NSW RURAL FIRE SERVICE

Your reference: SSD-5300
Our reference: S14/0039

Waste Resource Recovery Facility - 20 Wyllie Road, Kembla Grange

Reference is made to correspondence dated 27 May 2015 seeking comments in relation to a Response to Submissions (RTS) prepared in relation to the above proposal. The RTS provided additional information in relation to the location of combustible materials processing on the site and requested the removal of asset protection zones from the riparian corridor which traverses the site.

DRAWING TITLE
 Landscape Plan

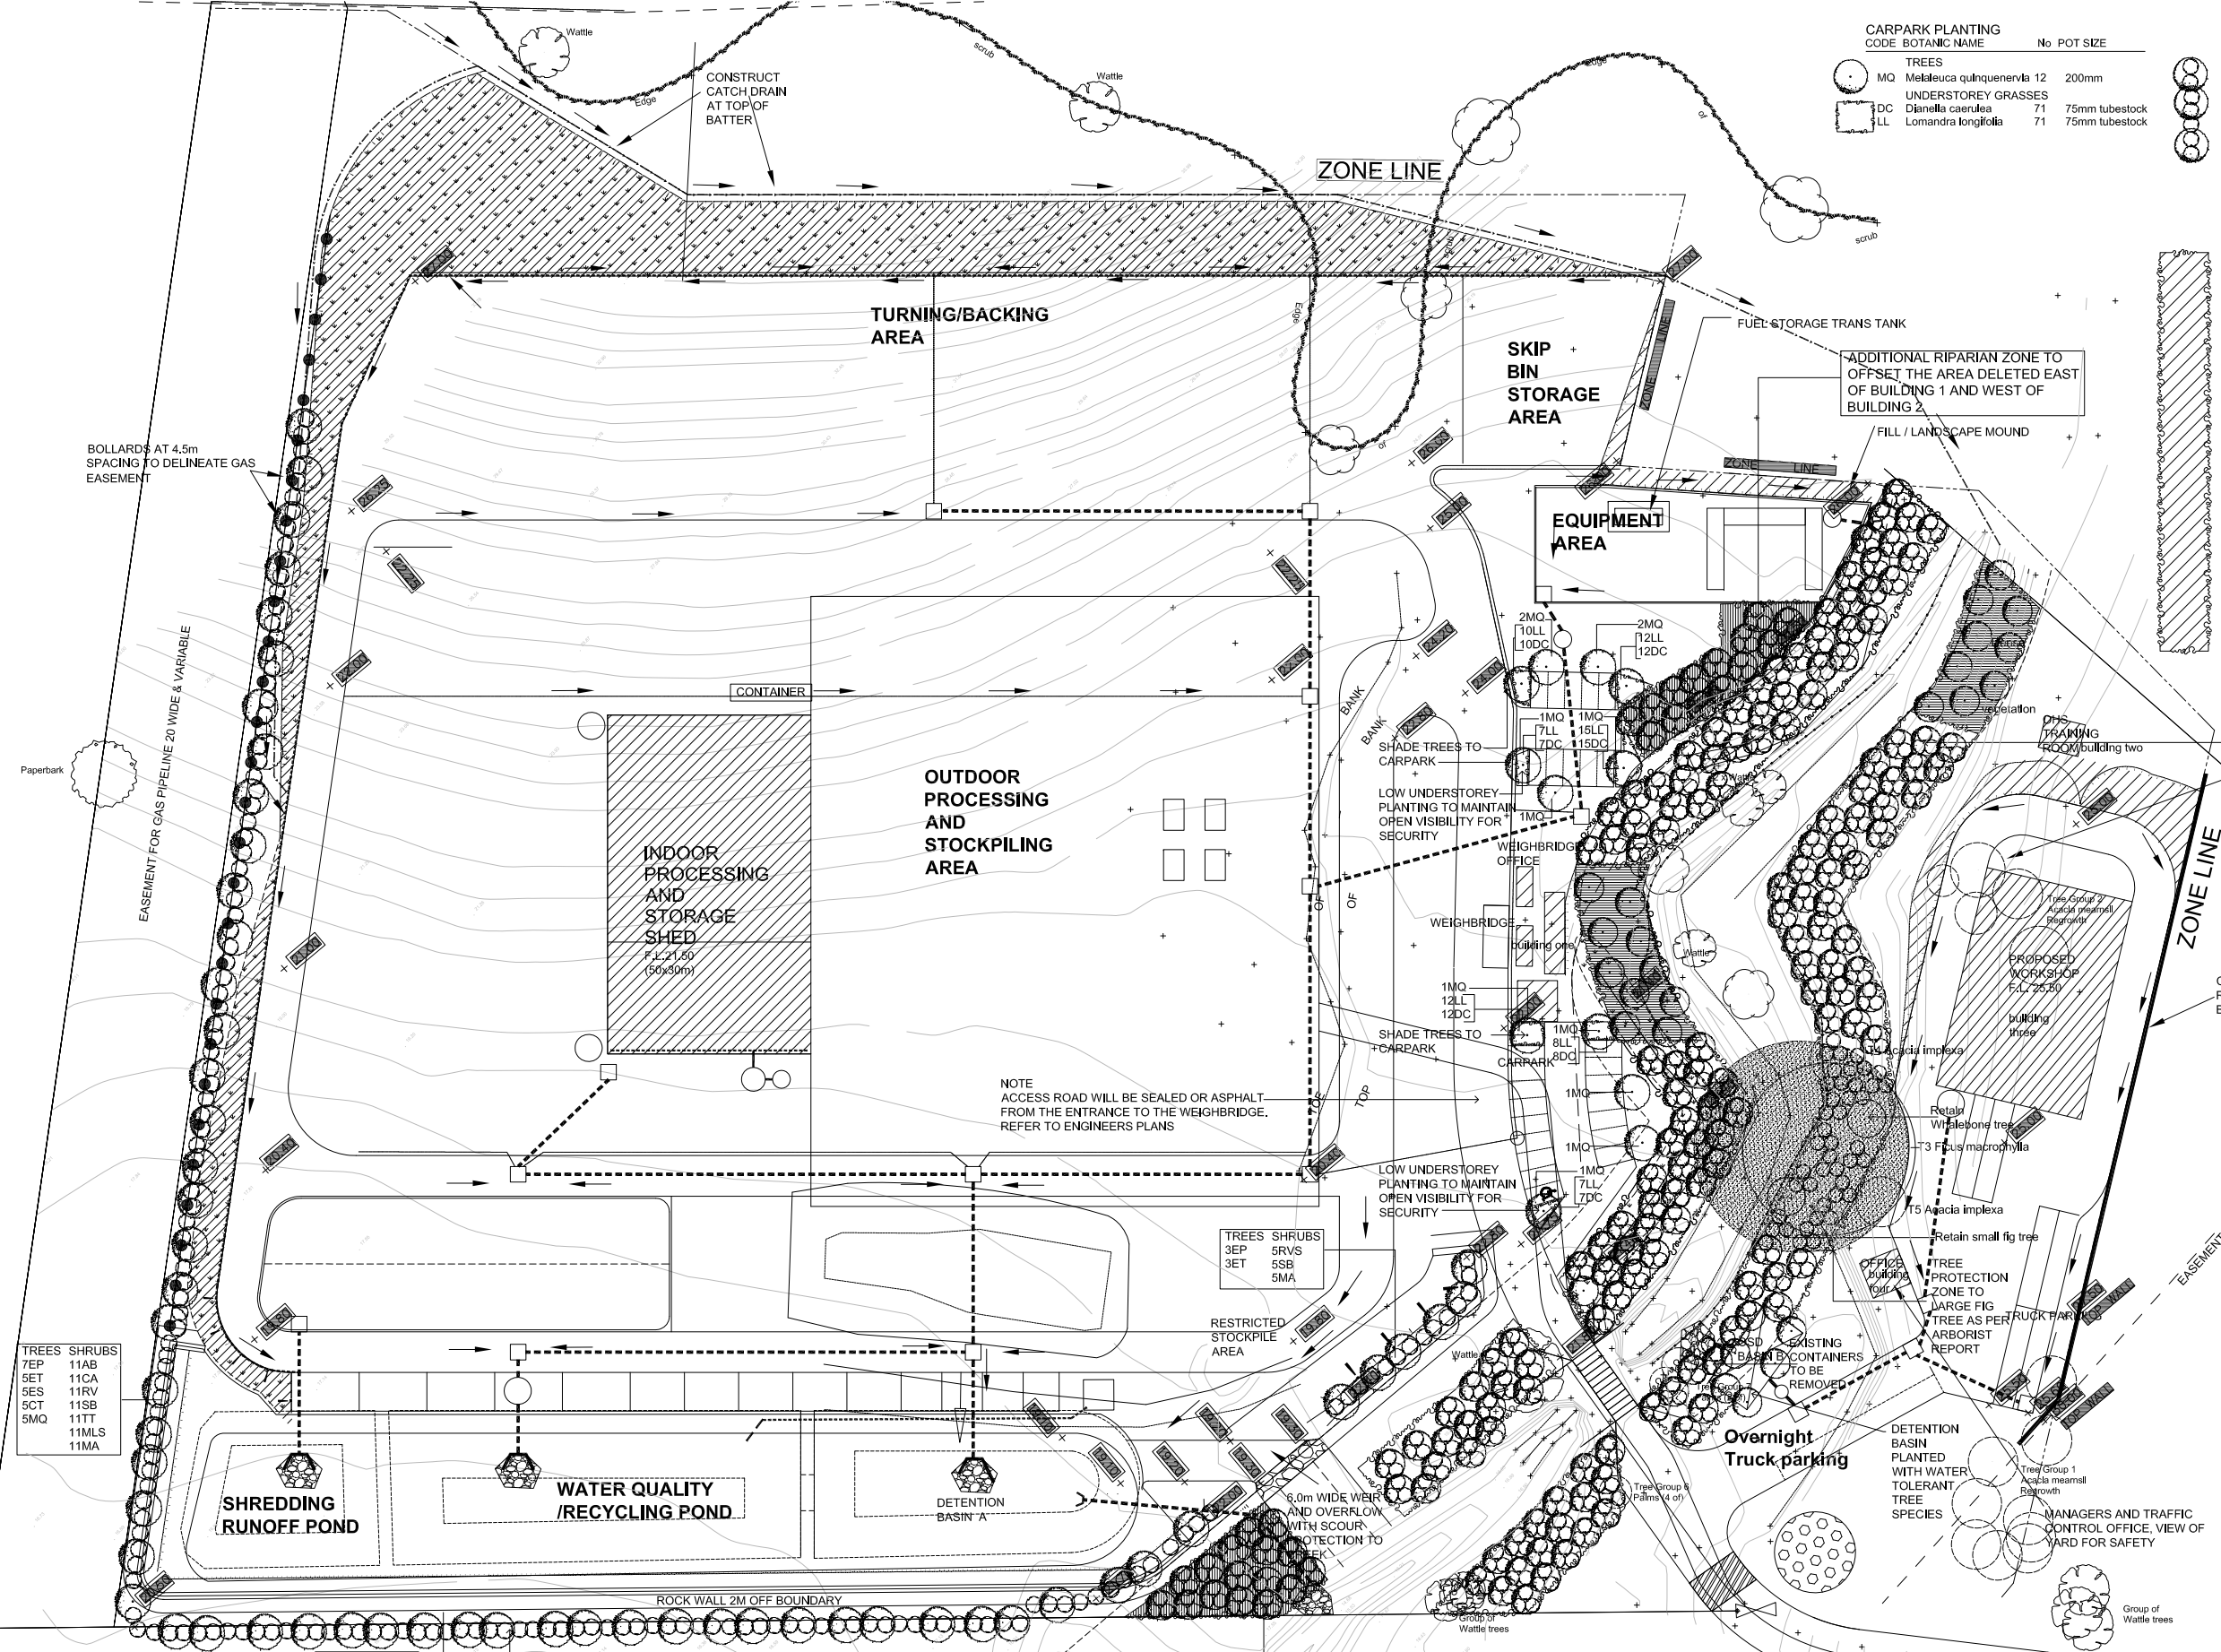
1. At the commencement of building works, and in perpetuity, the proposed facility shall be managed as an Inner Protection Area (IPA) as outlined within section 4.1.3 and Appendix 5 of 'Planning for Bush Fire Protection 2006' and the NSW Rural Fire Service's document 'Standards for asset protection zones'. This shall include the area around the proposed workshop building for a distance of 20 metres to the north and east but shall exclude the riparian corridor which traverses the facility.

9. Landscaping of the facility, excluding the riparian corridor, shall comply with the principles of Appendix 5 of *Planning for Bush Fire Protection 2006*.

Building H - Fire services

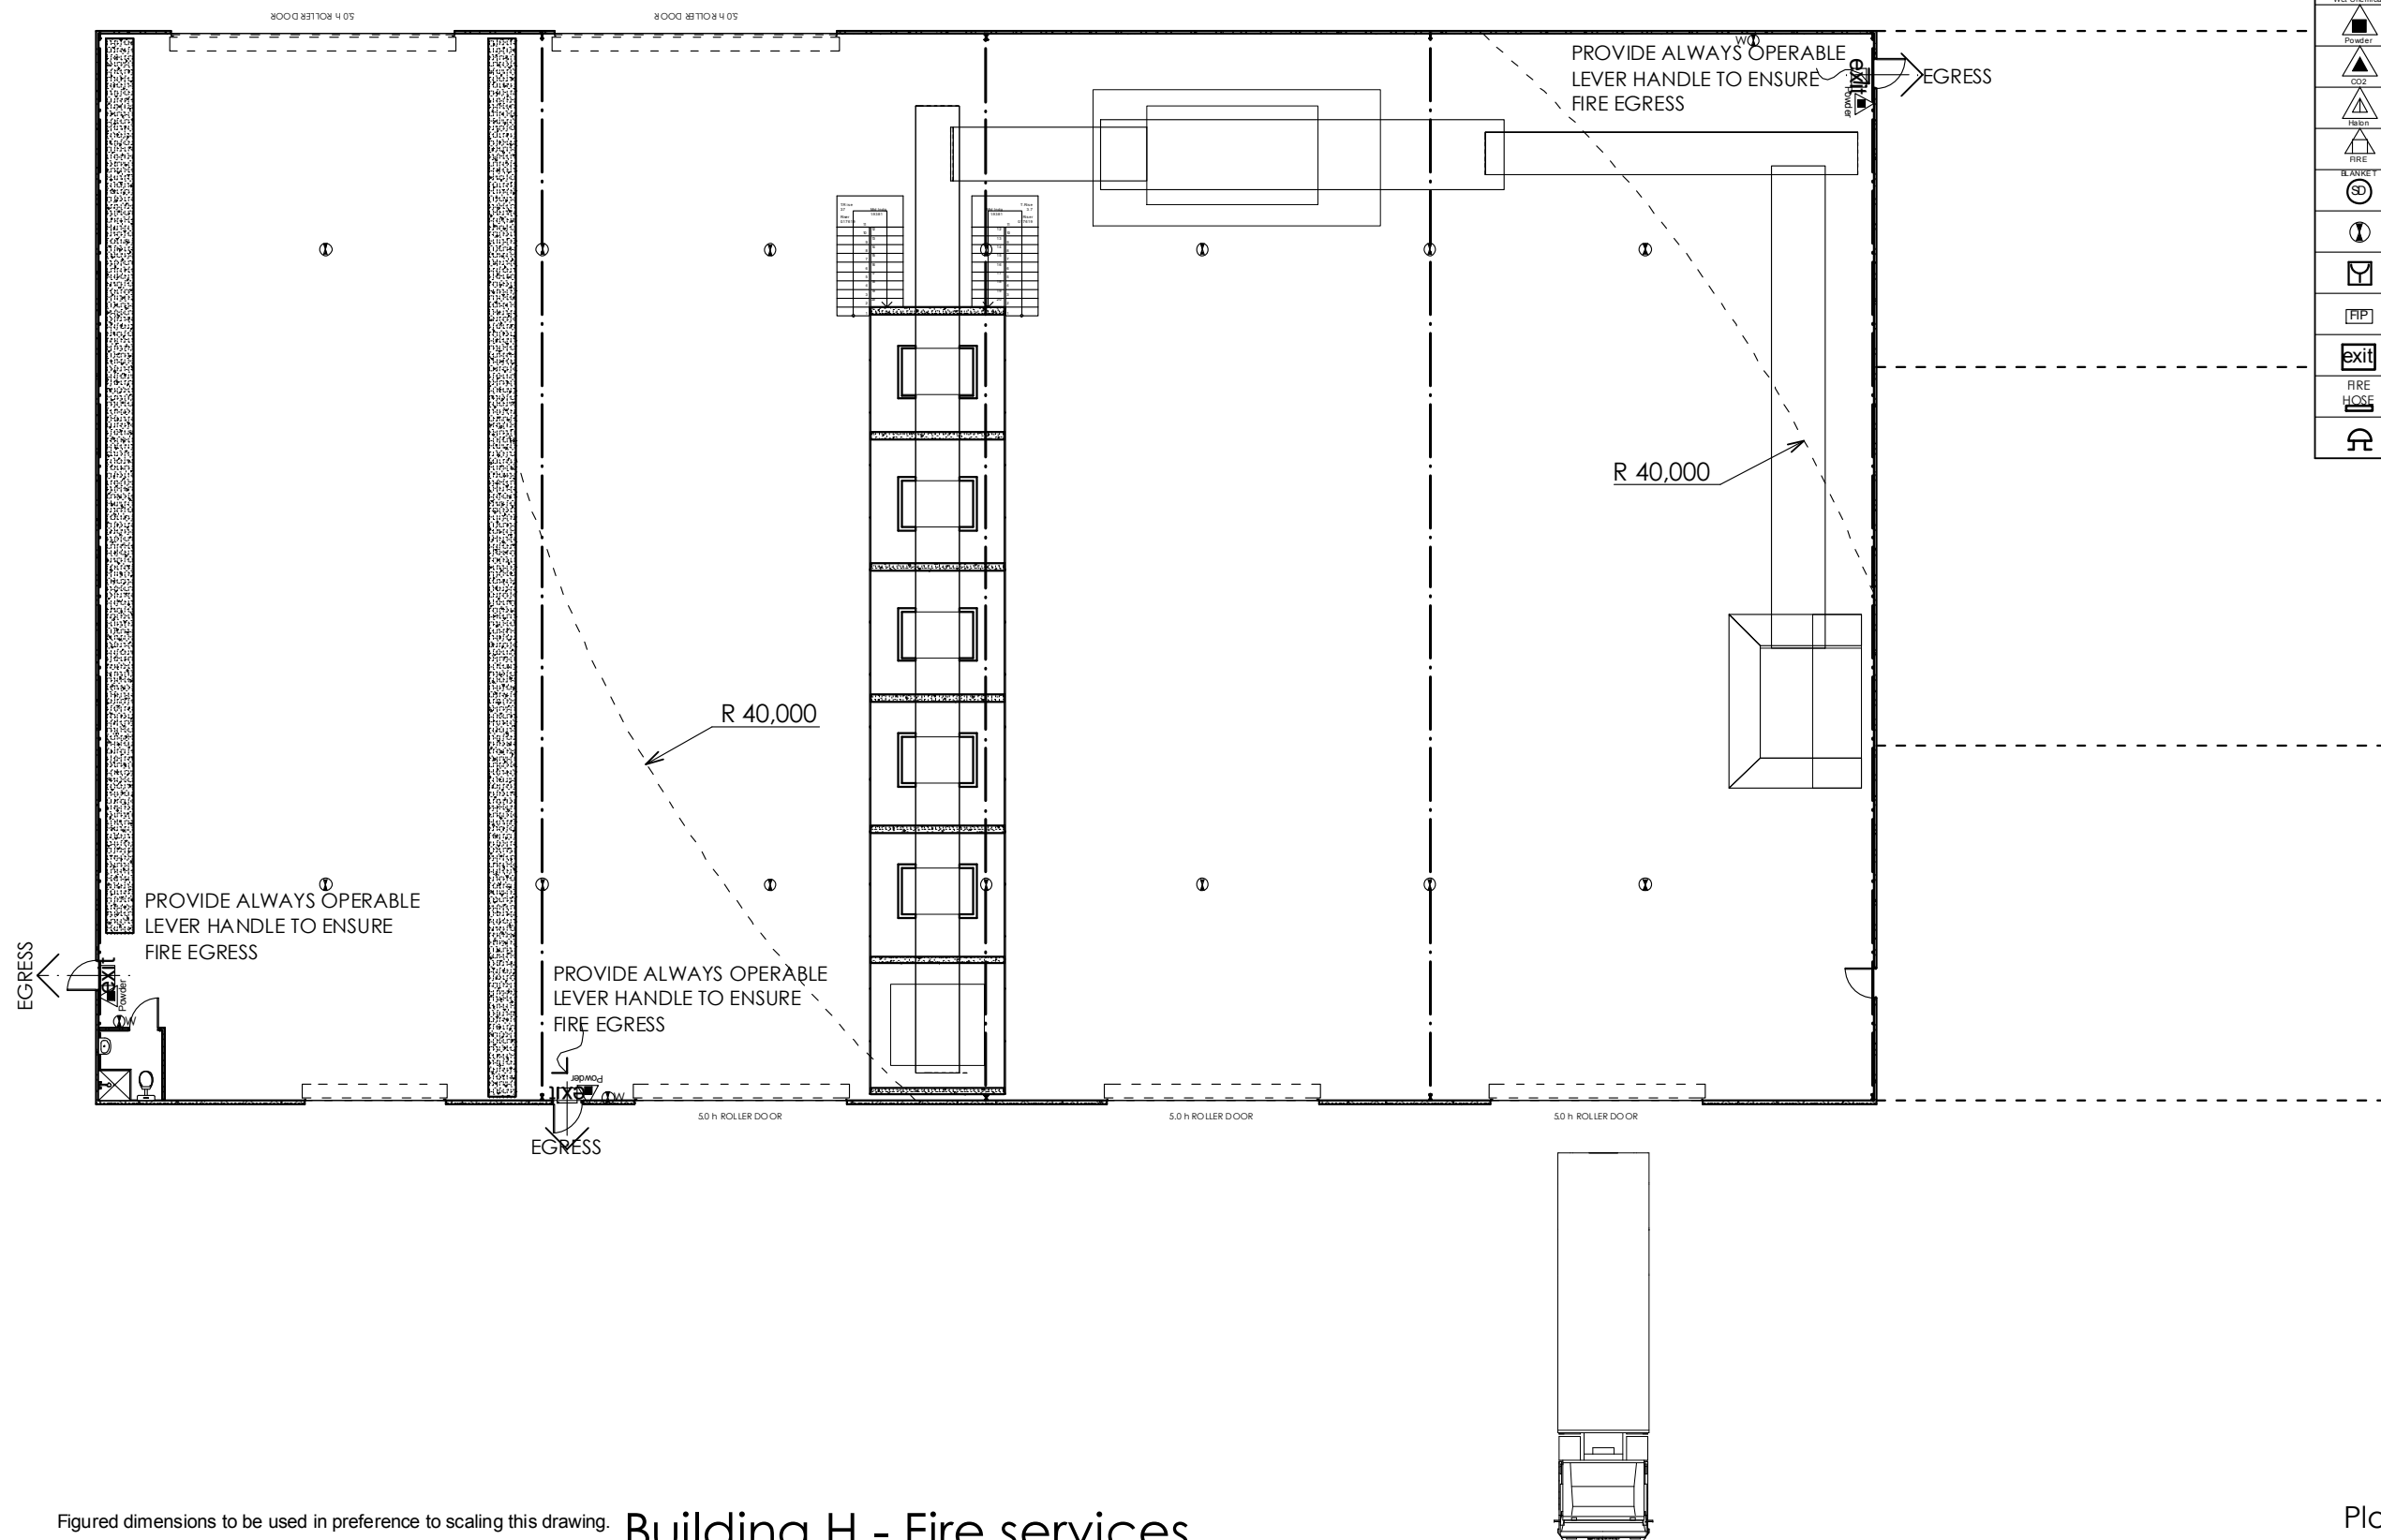
2. The north-eastern, north-western and south-western elevations, and roof structures, of the proposed office building shall comply with Sections 3 and 9 (BAL FZ) Australian Standard AS3959-2009 'Construction of buildings in bush fire-prone areas'. However, any material, element of construction or system when tested to the method described in Australian Standard AS1530.8.2 Methods for fire tests on building materials, components and structures Part 8.2: Tests on elements of construction for buildings exposed to simulated bushfire attack—Large flaming sources shall comply with Clause 13.8 of that Standard except that flaming of the specimen is not permitted and there shall be no exposed timber.

3. Window assemblies on the north-eastern, north-western and south-western elevations of the proposed office building shall comply with modified Sections 3 and 9 of AS3959 (as above) or the following: i. They shall be completely protected by a non-combustible and non perforated bushfire shutter that complies with Section 3.7 of AS3959 excluding parts (e) & (f); and ii. They shall comply with the following: a) Window frames and hardware shall be metal; b) Glazing shall be toughened glass, minimum 6mm; c) Seals to stiles, head and sills or thresholds shall be manufactured from materials having a flammability index no greater than 5; d) The openable portion of the window shall be screened internally or externally with a mesh with a maximum aperture of 2mm, made from corrosion resistant steel or bronze. The frame supporting the mesh shall be metal.

4. External doors on the north-eastern, north-western and south-western elevations of the proposed office building shall (not including garage doors) shall comply with modified Sections 3 and 9 of AS3959 (as above) or the following: i. They shall be completely protected by a non-combustible and non perforated bushfire shutter that complies with Section 3.7 of AS3959 excluding parts (e) & (f); and ii. They shall comply with the following: a) Doors shall be non-combustible; b) Externally fitted hardware that supports the panel in its function of opening and closing shall be metal; c) Where doors incorporate glazing, the glazing shall be toughened glass minimum 6mm; d) Seals to stiles, head and sills or thresholds shall be manufactured from silicone; e) Doorframes shall be metal; f) Doors shall be tight fitting to the doorframe or an abutting door; g) Weather strips, draught excluders or draught seals shall be installed if applicable.

5. The south-eastern elevation of the proposed office building shall comply with Sections 3 and 8 (BAL 40) Australian Standard AS3959-2009 'Construction of buildings in bush fire-prone areas' and section A3.7 Addendum Appendix 3 of 'Planning for Bush Fire Protection 2006'.
